RE: UUNGULA WIND FARM _ SSD 6687

Submission in response to the E.I.S proposal for CWP Pty Ltd at Wellington. Uungula Wind Farm by the Wellington Branch of NSW Framers Association on behalf of the Users of Twelve Mile Road.

Figure 2 | Twelve Mile Road / Goolma Road Intersection Design

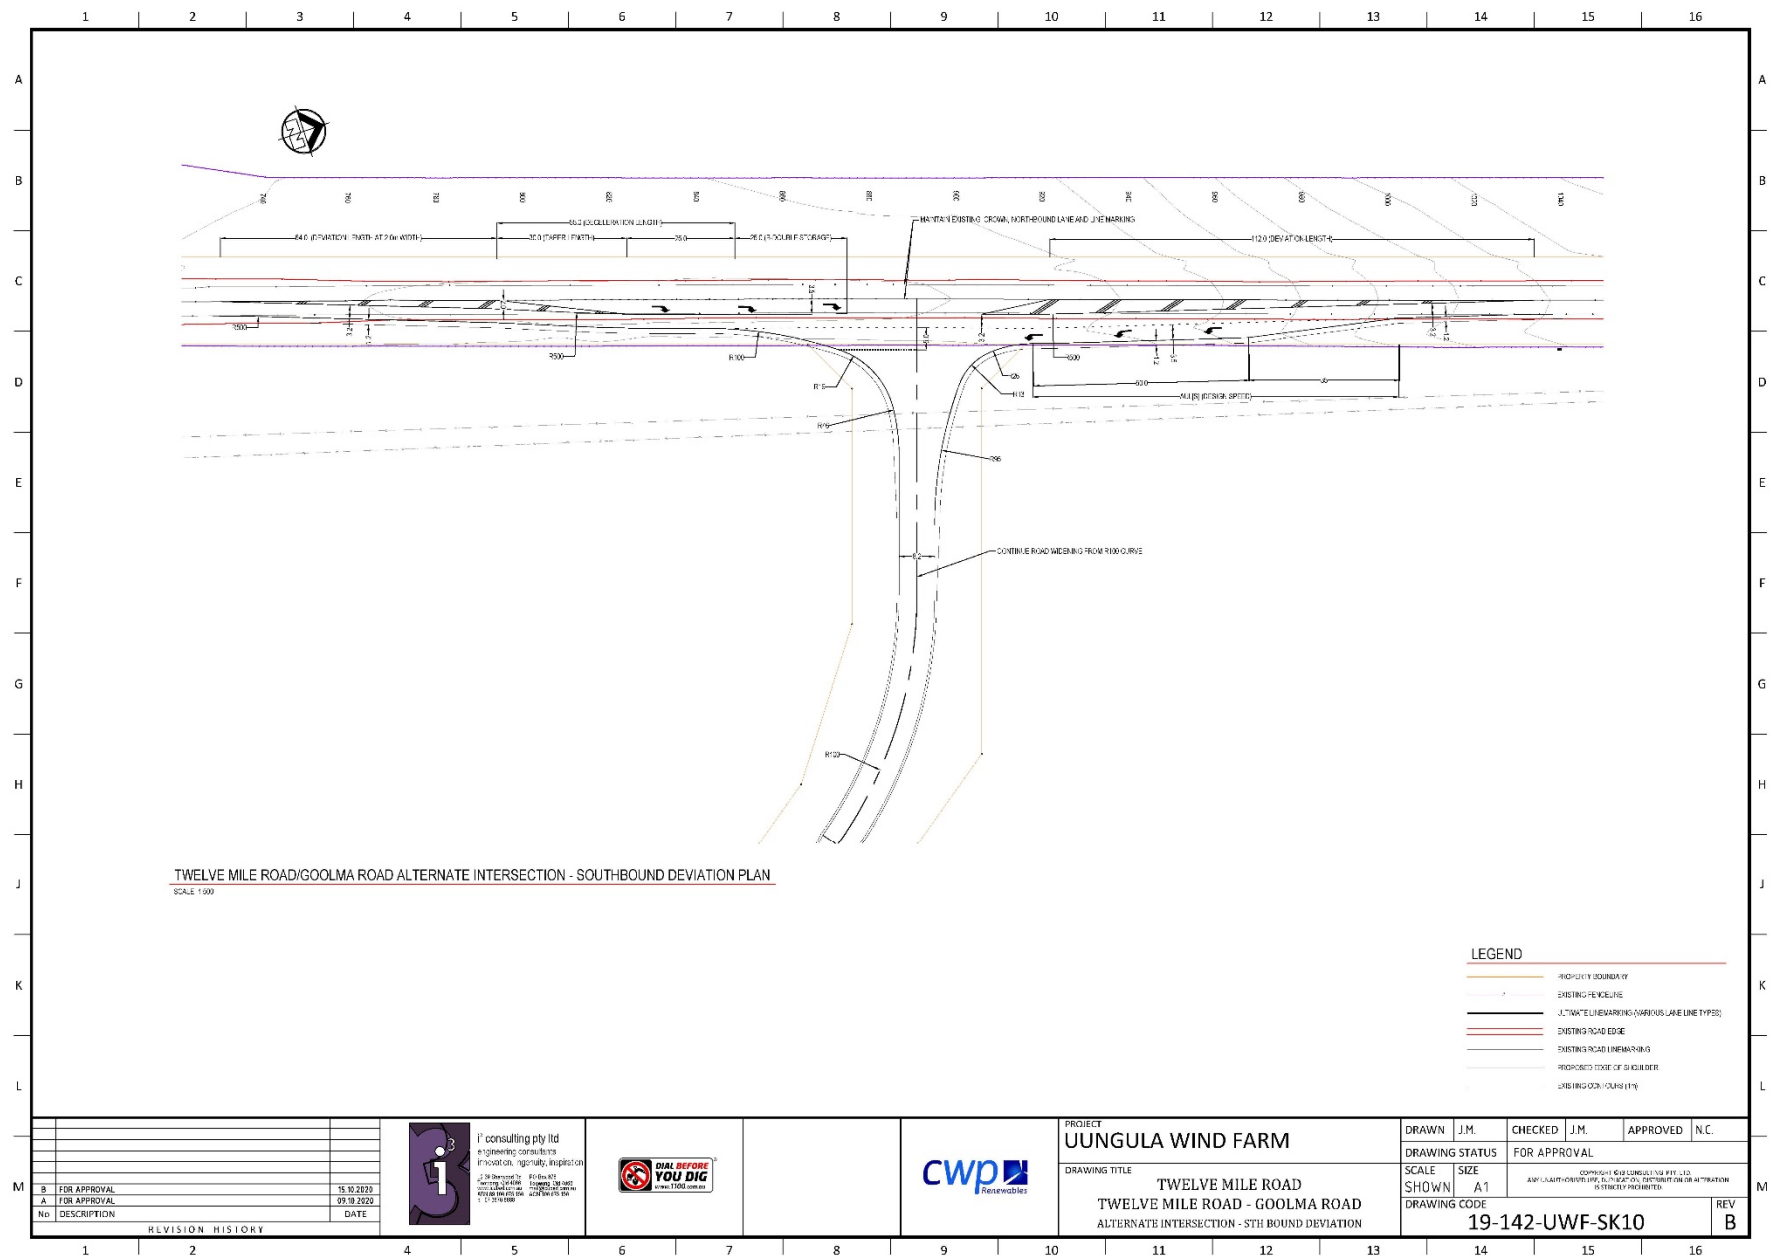
We would like to address the EIS proposal for changes to "Cadonia Corner" as set out in the "I-Cubed appendix N."

This proposal appears to be a "hybrid" soloution pandering to the penchant of Roads Authorities for classical "T-Intersections" and still allowing CWP to build their wind farm. It would be more believeable if it recommended the OSOM vehicles enter Twelve Mile Road by the tortuous route suggested for Twelve Mile Road users instead of the straight road ahead as appendix N proposes.

i. Entering Twelve Mile Road from Wellington

Instead of the “i-cubed” recommendation of a dangerous right angle turn into the intersecting track we propose the deceleration lane in the appendix N be moved towards Wellington 100metres (the length of the straight section on Twelve Mile Road). In addition users of the Twelve Mile Road have complained to us that the through lane on the left (North) needs to be wider to allow the through traffic to proceed towards Goolma. There is ample room for this and visibility is greater to 350metres. Merging traffic is always safer than crossing the oncoming lane of traffic.

ii. Exiting Twelve Mile Road towards Wellington

Road users have all recommended that there be an accelerating lane to the left (Sth) side of the through traffic lane to allow vehicles to gain enough speed before joining the traffic. There is plenty of room for such a lane.

iii. Entering Twelve Mile Road from Goolma

The “i-cubed” report has recommended a deceleration lane to the left (Sth) of the through traffic lane and a rounding off of the corner leading into the intersecting track. We agree with this but stress that the deceleration lane be level not a continuation of the severe camber on the major road (Goolma Rd). There is plenty of room for this lane.

iv. Exiting Twelve Mile Road towards Goolma

No matter how this turn is approached it will always be the most dangerous procedure at this intersection. This is because the major road is severely cambered to the North, is on a significant curve and because visibility towards Goolma is only 250metres. The visibility problem could be made less dangerous by signage both in the road surface and standing signs either limiting speed to 60 or 80KPH or indicating “Turning Traffic” and demanding SLOW DOWN.

Appendix N does not recommend an acceleration lane for vehicles proceeding towards Goolma to gain some speed before merging with Goolma bound traffic. It does have an area marked as below which could be the start of an acceleration lane which our advice indicates should ideally be 500metres.

Certainly, it would not be much use if it did not travel the 250metres to the top of the adjacent hill. There is plenty of room on the roadside for this very important addition to the intersection.

Regarding the “I-cubed” proposal for Wellington traffic Twelve Mile Road bound to pull up in the middle of the road and turn into the intersecting track NSW Farmers in representing the views of the Twelve Mile Road Users has found not one person who wished to see that particular “I-Cubed” recommendation acted upon. In addition, opinion from the same or similar road users over the past 50 years has unanimously rejected that or similar proposals.

Given the above arguments we would like to insist that Development Consent be dependant upon this intersection being properly upgraded to cope with the vastly increased volume and style of traffic and that under no circumstances do the users of Twelve Mile Road end up with a dangerous quasi T-section entry into the intersection track instead of a straight run into the Twelve Mile Road as it is now.
